H11-0389-22

Consultee Name:	Sue Armour
Address:	Environmental Protection Officer SHDC
Date Transferred:	Unrecognised Format
Planning Officer:	Lucy Buttery
Response Type:	Comments

The report submitted (Humberside Materials Laboratory Ltd 'Phase 1 & 2 site investigation report Land off Seagate Road, Long Sutton' 1197/5350/P/P2 rev 1.0 dated November 2021 plus Appendix D and Appendix E) relates to a significantly larger site and a different development layout, and I have therefore only considered parts of the report that relate to the area covered by application H11-0882-21 in these comments. Whilst I am in general agreement with the findings,

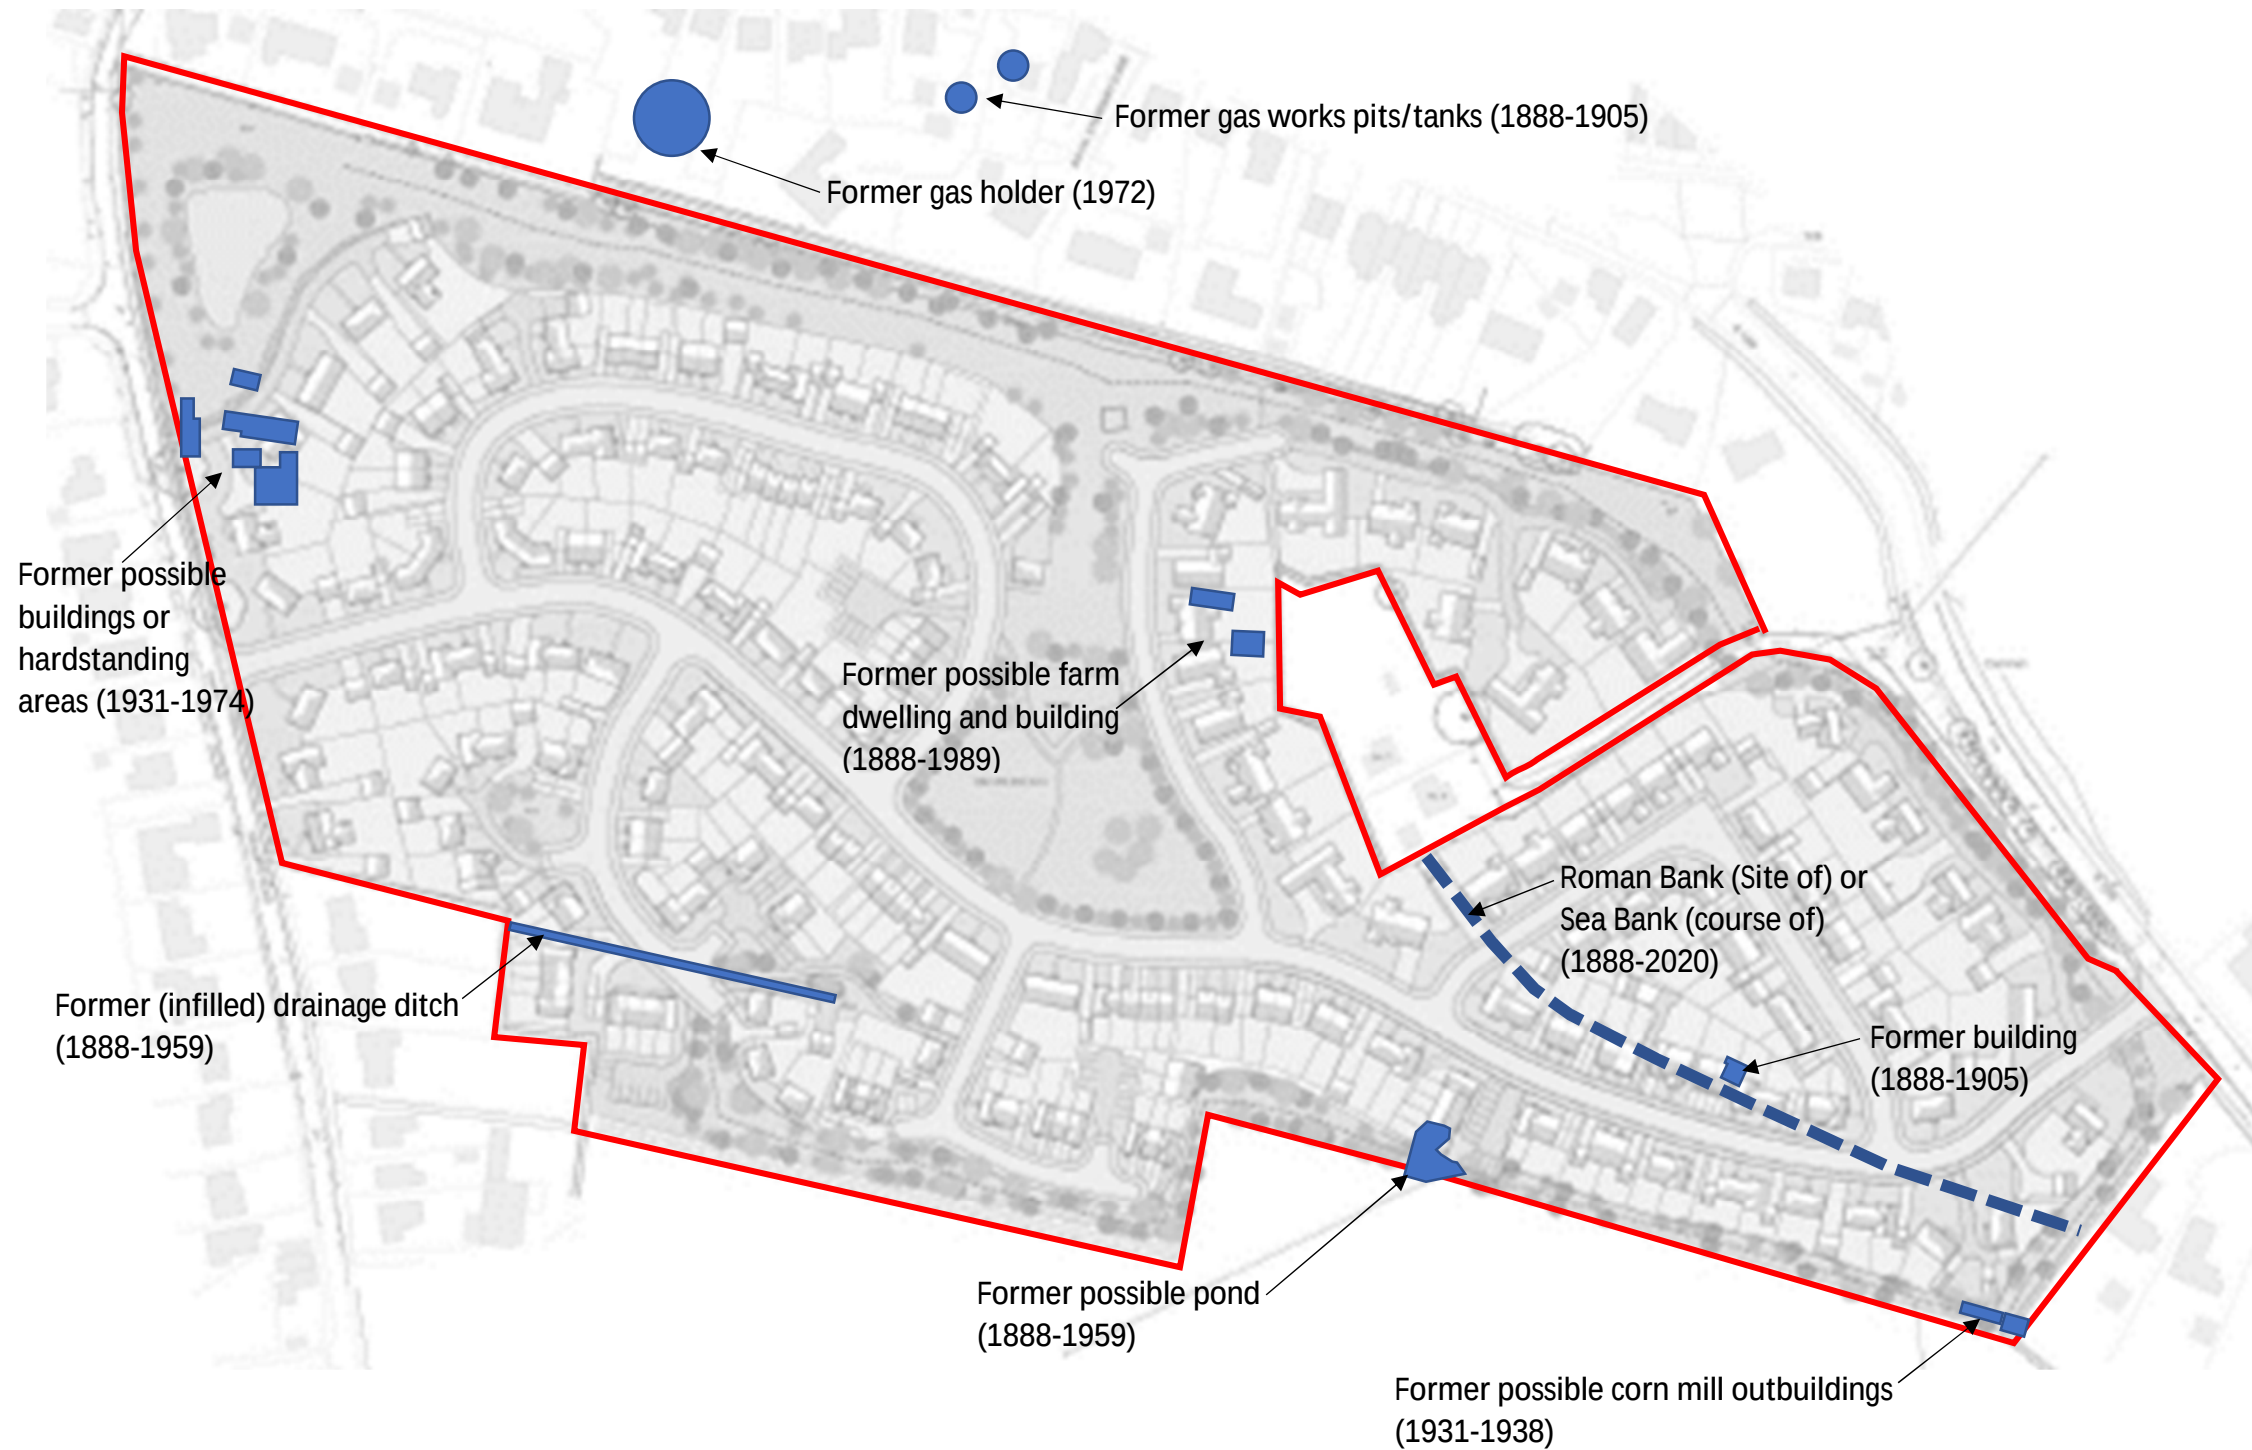
the report does not identify the former running lines and signal point of the railway which used to run through the northern part of the site as a potential source of contamination. There was subsequently no site investigation in this area, either in the current redline boundary or in the larger area covered by the report, to know if all the material used to make up the track bed was removed. Track beds can contain elevated levels of fuels and poly aromatic hydrocarbons as well as metals. Looking at the current development plan (LDC-3598-PL-12 C Proposed Site Plan) please can some clarification as to the nature of the proposed land use in this area be given and this be considered in the context of the conceptual model?

With regards to your email below, and the comments made by the EPO, we can confirm that the area described (hatched in grey below) is purely used as an easement for the nearby pipes and no dwelling works are to take place there. The gates access shown was simply to allow for maintenance.
